Application for approval of matters reserved by condition imposed under AL/39/13 relating to Condition No. 4 (materials), 6 (Tree retention plan), 12 (Landscaping), 14 (Ecological enhancement & management scheme), 15 (Lighting scheme), 16 (Construction management plan), 18 (Visibility splays), 19 (Construction management plan), 20 (Refuse & recycling), 23 (Archaeological investigation) & 25 (Green travel plan)

Land off Hook Lane Hook Lane Westergate

Thank you for your internet representation made on 12th February 2017 which has been recorded as **'an objection'** with the comments as follows:

Appendix B – Traffic Management Route

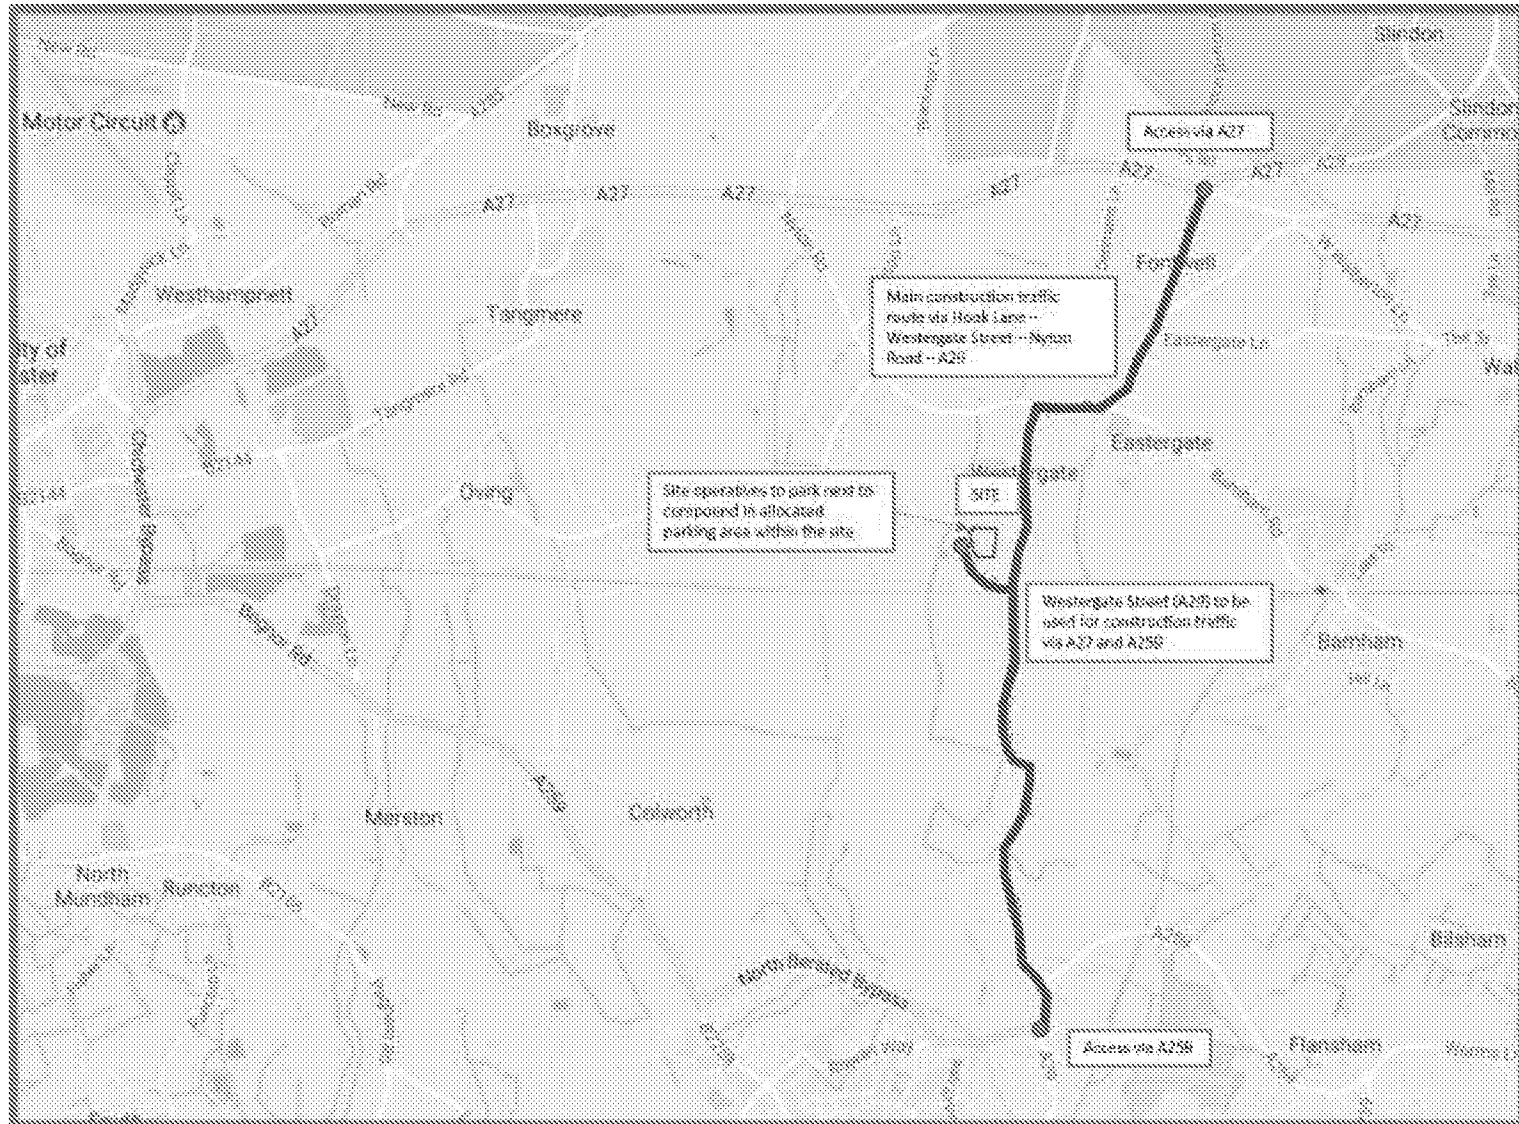
The proposal for site traffic to access the site from Oving Road is dangerous and ridiculous. The road is too narrow. At the end adjoining Oving Road there are two blind corners and the road width is down to little more than the width of the average car. 40 ton trucks will struggle along the whole length of the road and there will be no vehicles able to pass in the opposite direction as there is not sufficient road width. One or the other vehicle will have to reverse to the nearest driveway as the verges are soft and unable to support vehicles of any size. Turning right at the end of Hook Lane to reach the A27 is dangerous due to the very limited vision of traffic coming from Oving.
